Reference: Engineering Services
Anderson Creek – Lot 1138
Permit #SFD2505-0116
96 Graduate Court
Spring Lake, NC 28390
TE&D Project No.: 2501-020487_A

As requested by the builder, a representative of Tyndall Engineering & Design, PA (TE&D) was on-site to observe the following items as noted by the Building Inspector:

**S-1c**  
STEM WALL  
FOUNDATION PLAN

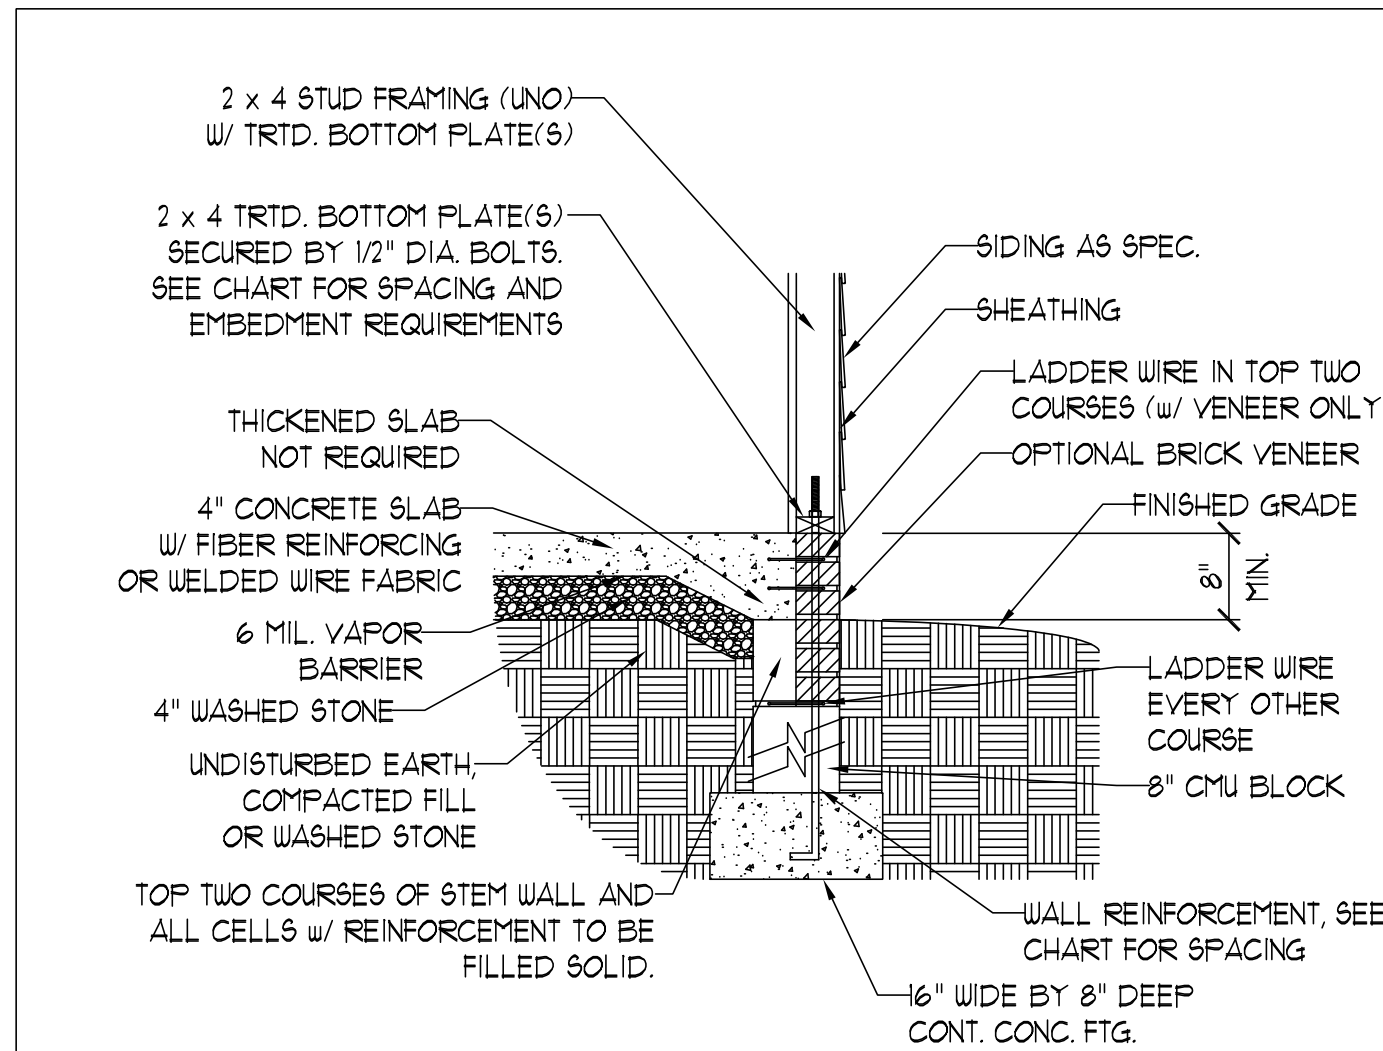
- 3) We observed the front porch foundation was constructed with 8" CMU block to heights of 32" to 40" above the footing. We understand the porch was fully backfilled with #57 washed stone. Based on our observations and analysis, the porch foundation and backfill will provide the required support for the anticipated loading conditions.

S-2  
SECOND FLOOR  
FRAMING PLAN

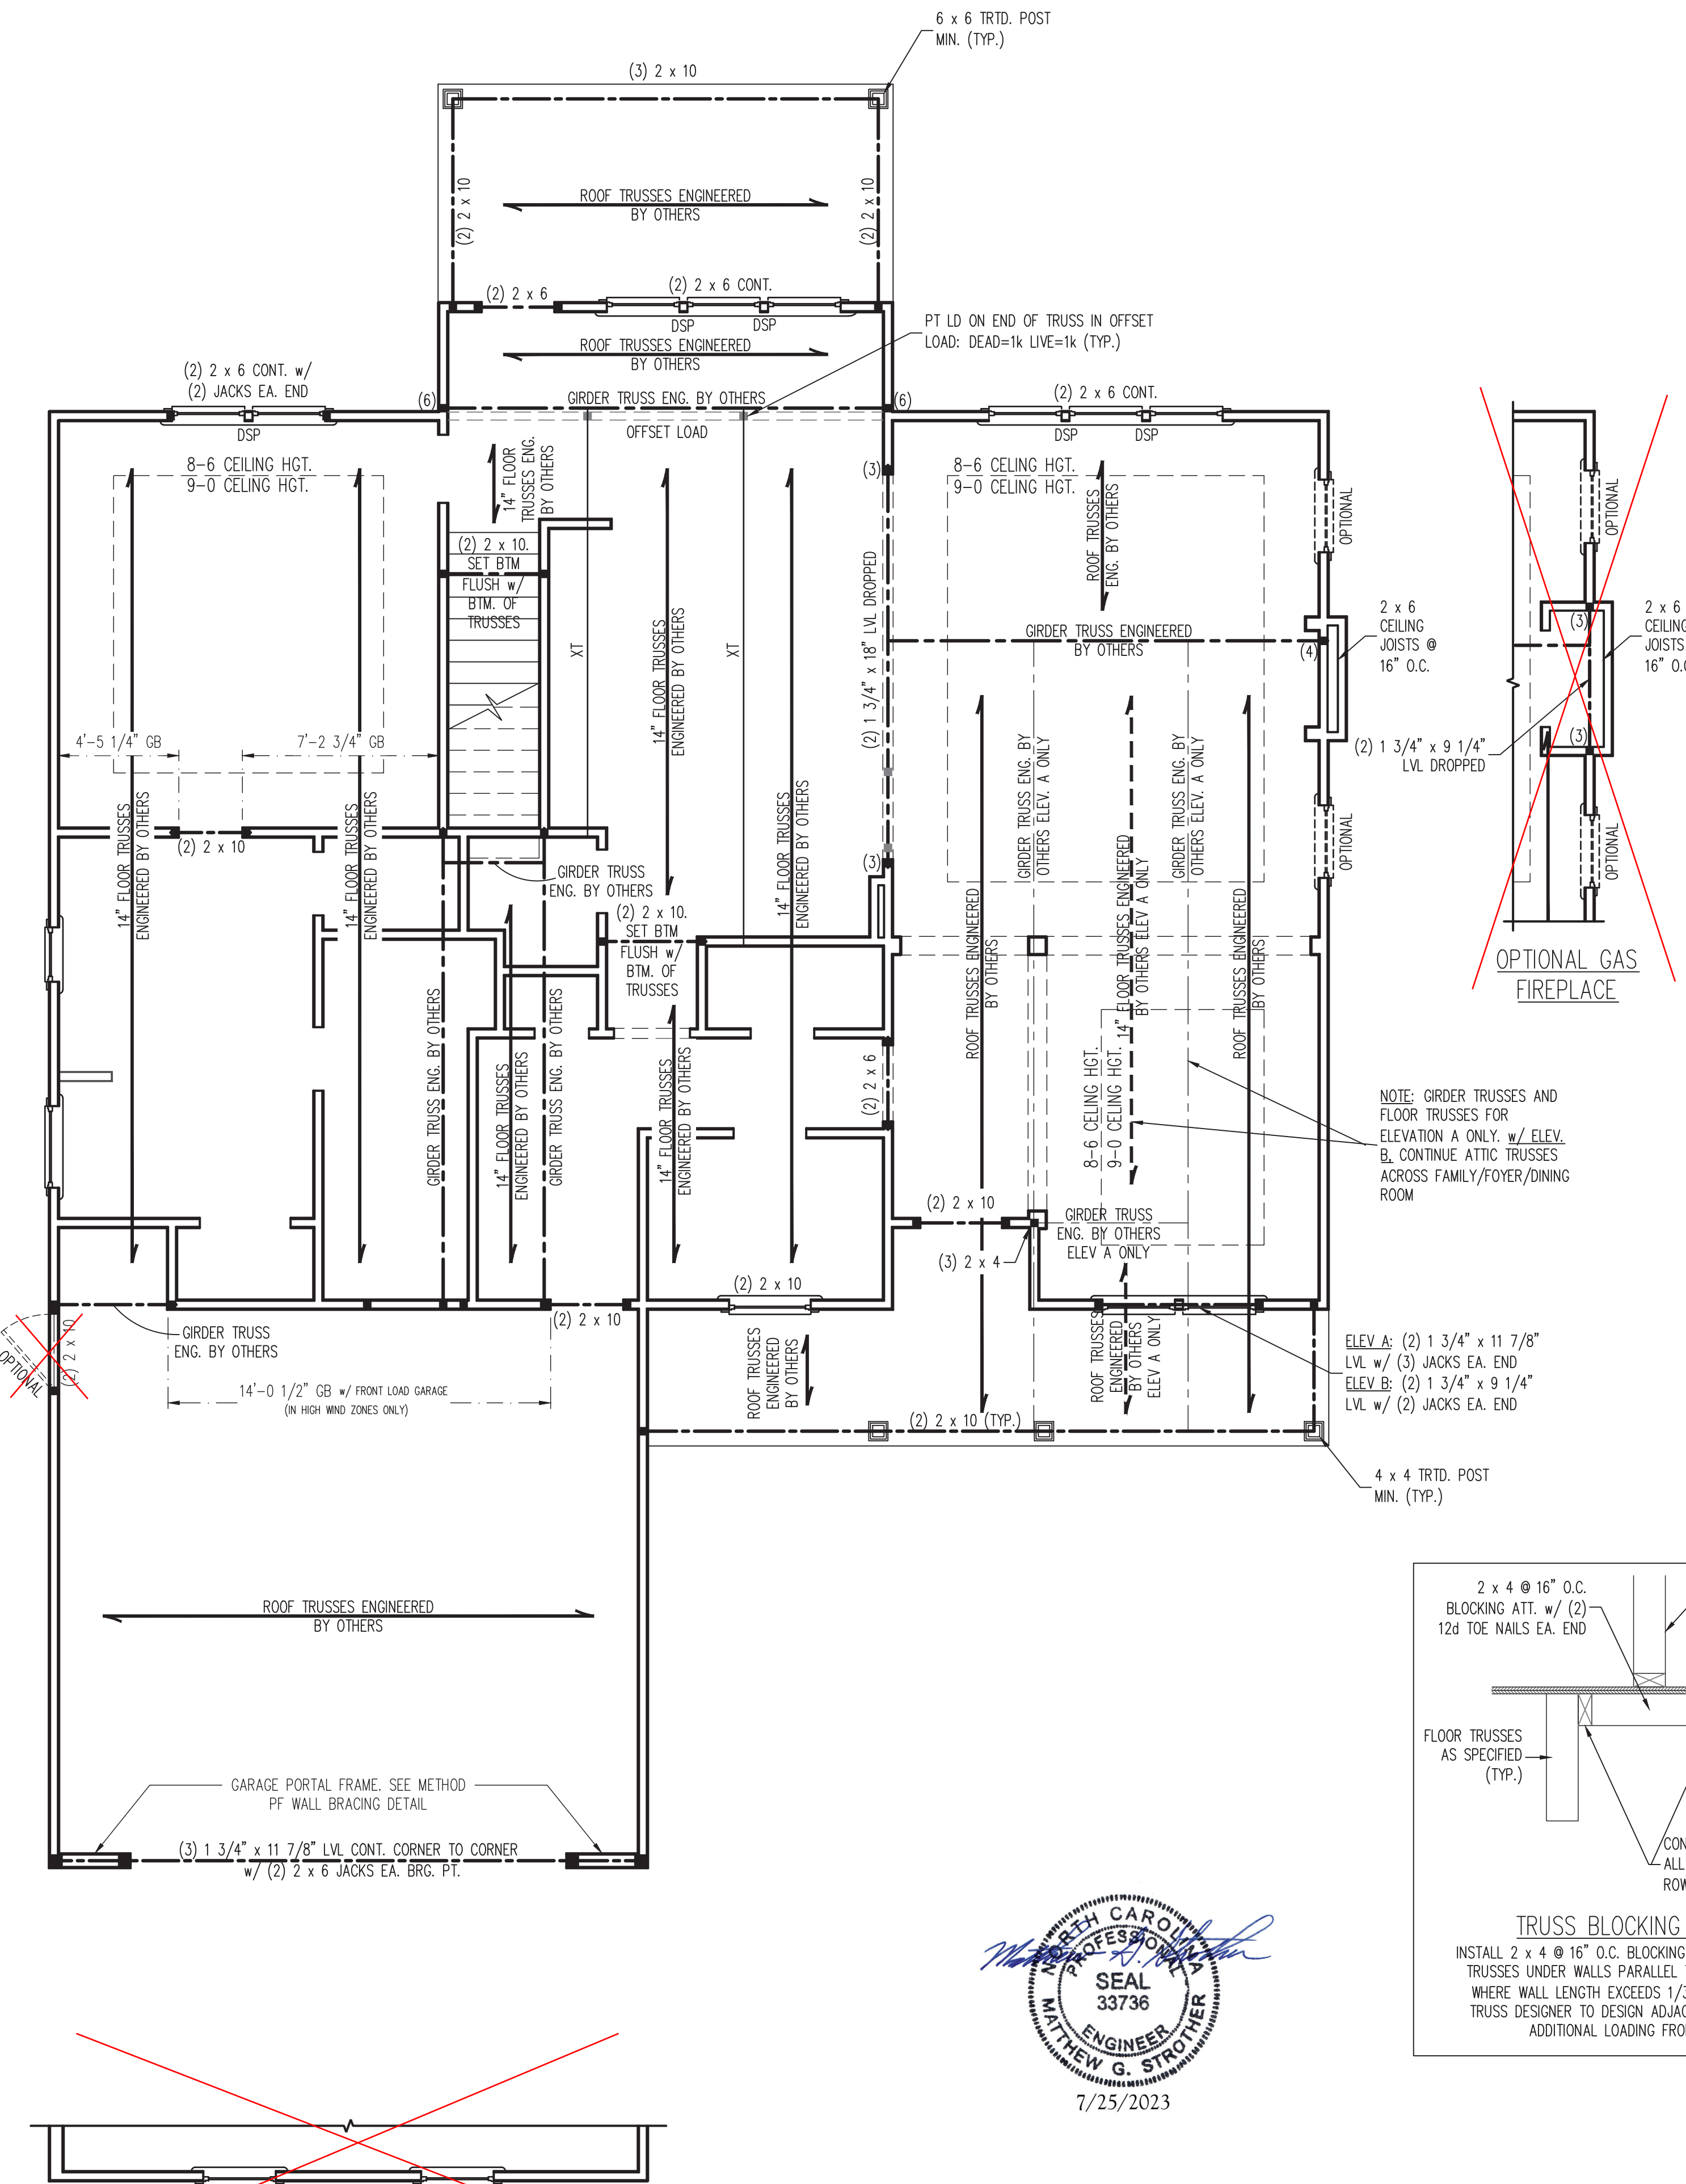
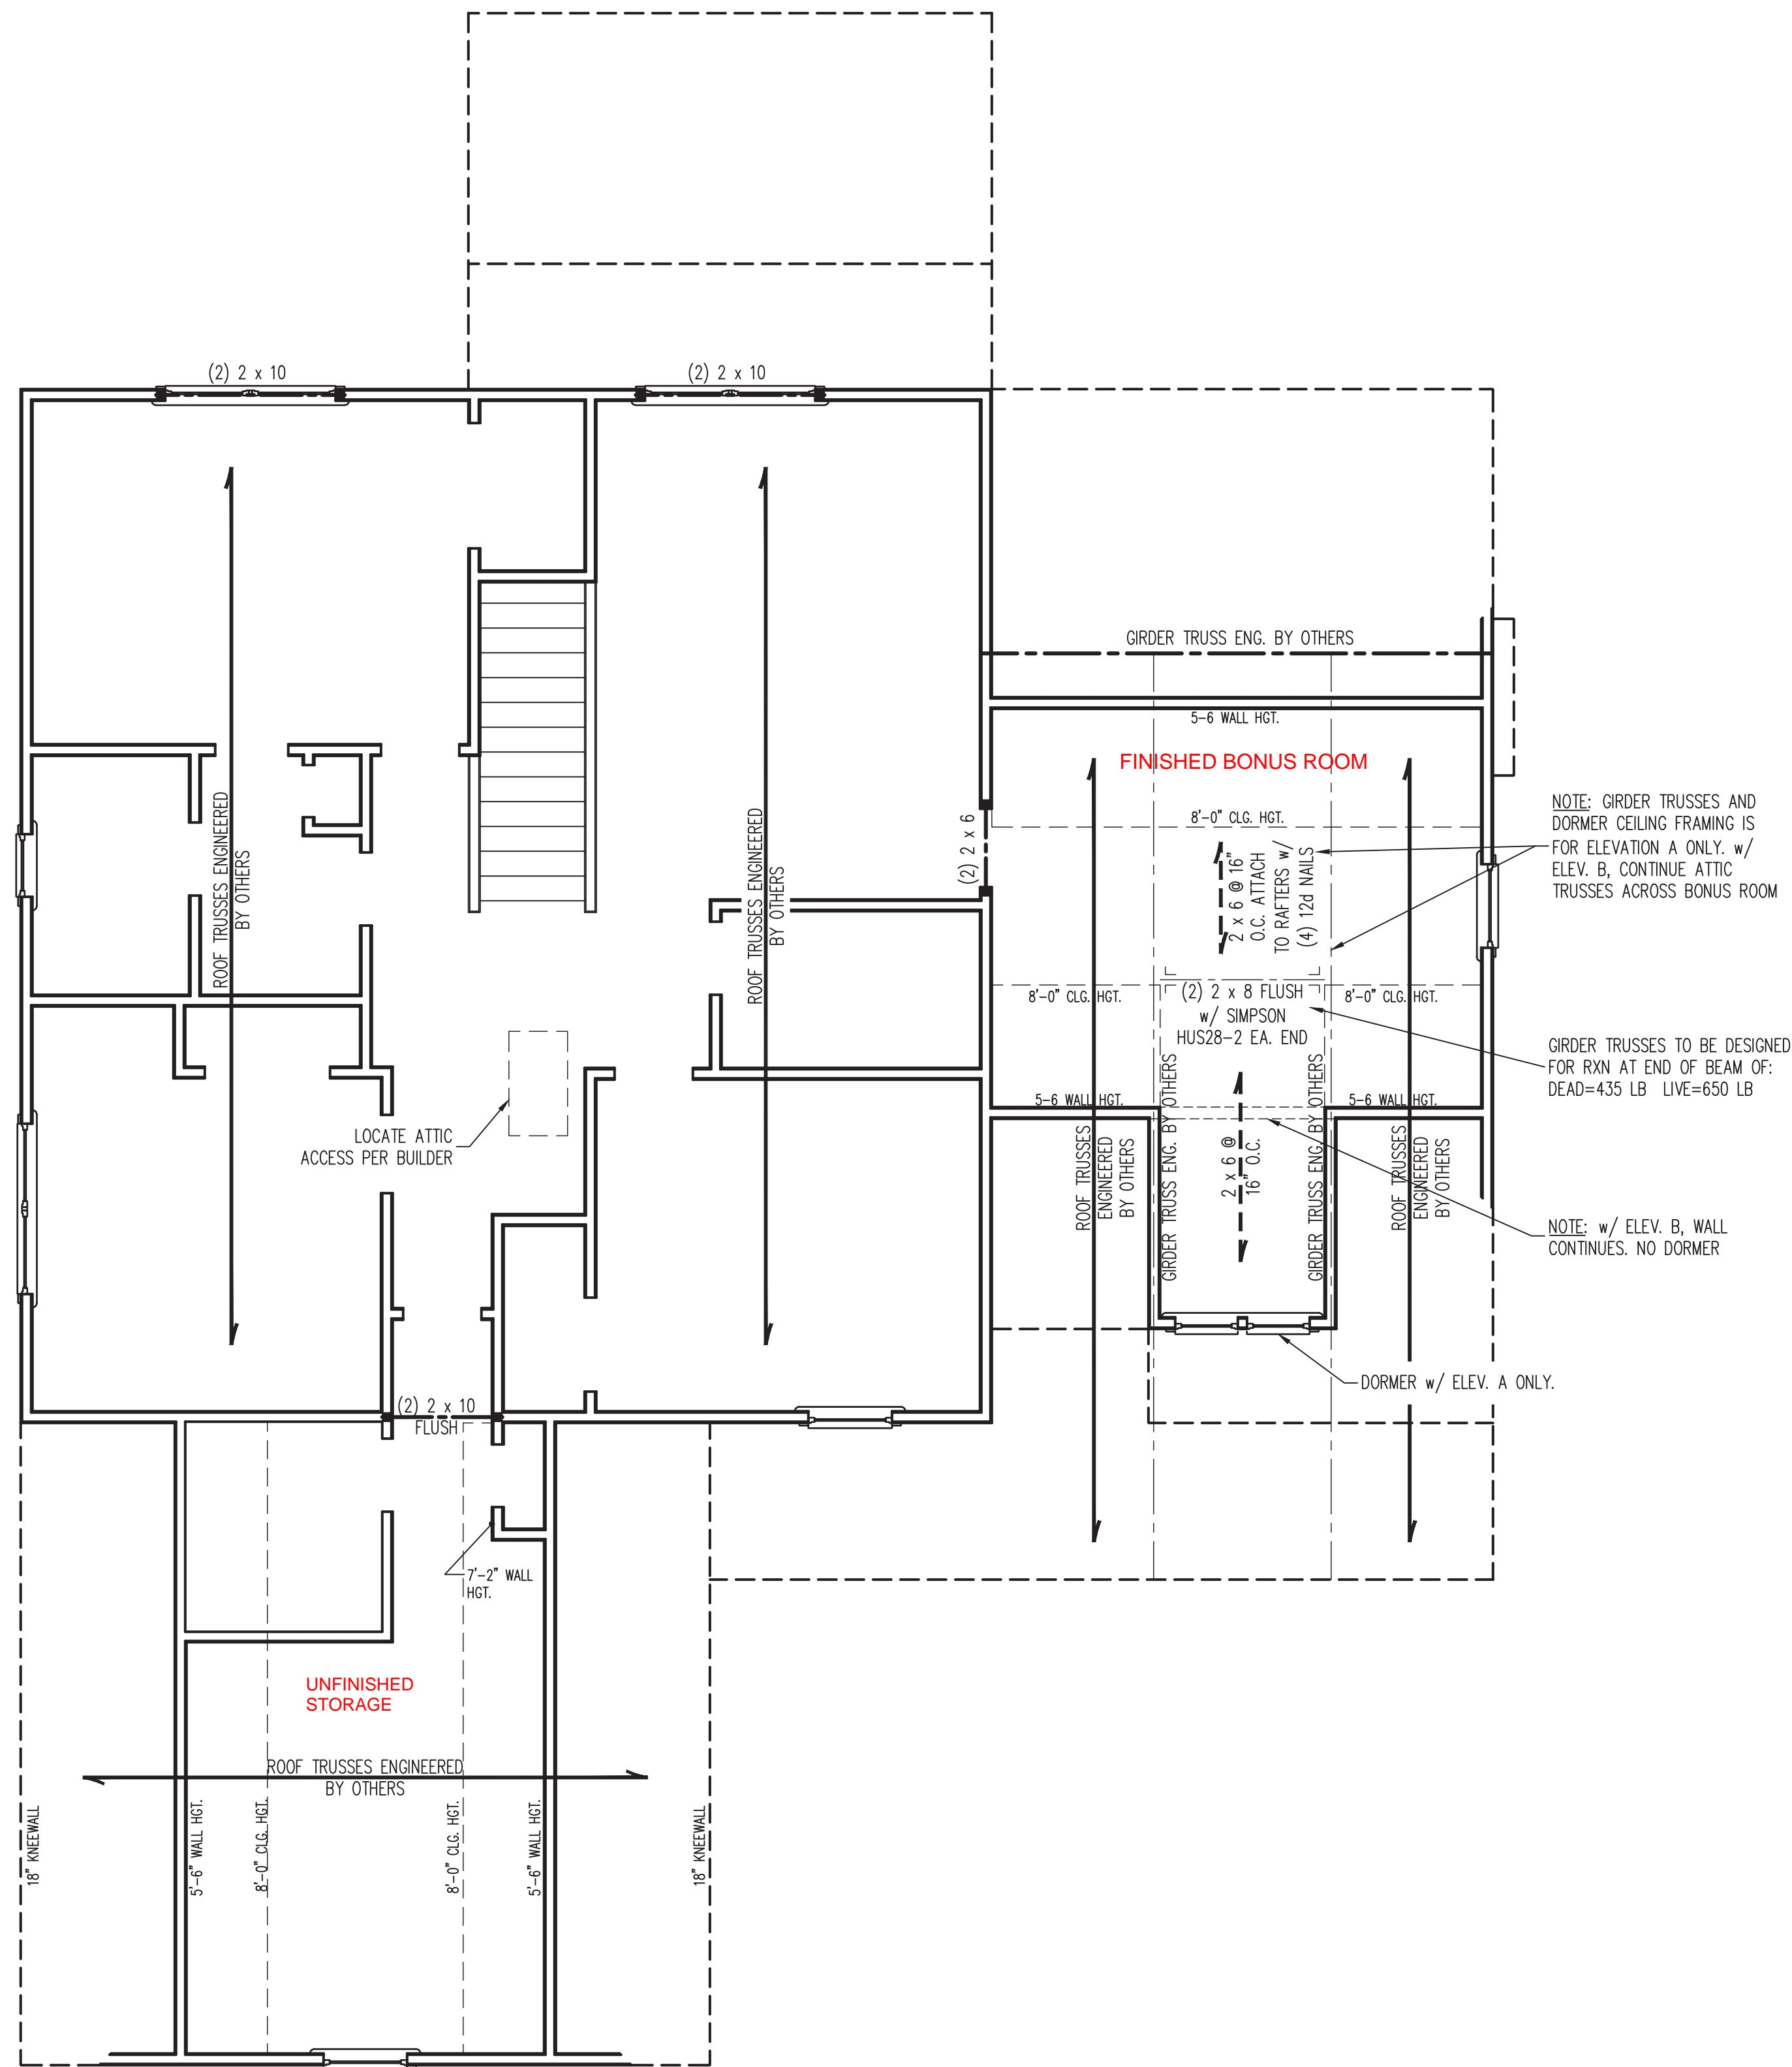
- 1) Missing air barrier in garage ceiling under knee walls.
- 2) Missing front porch flashing.
- 3) Front porch fill to be certified by an engineer.
- 4) 4-ply girder truss missing 1/2" through bolts.

- 1) We observed solid blocking was installed within the garage ceiling under the knee walls above. We recommend all holes be filled with spray foam insulation.
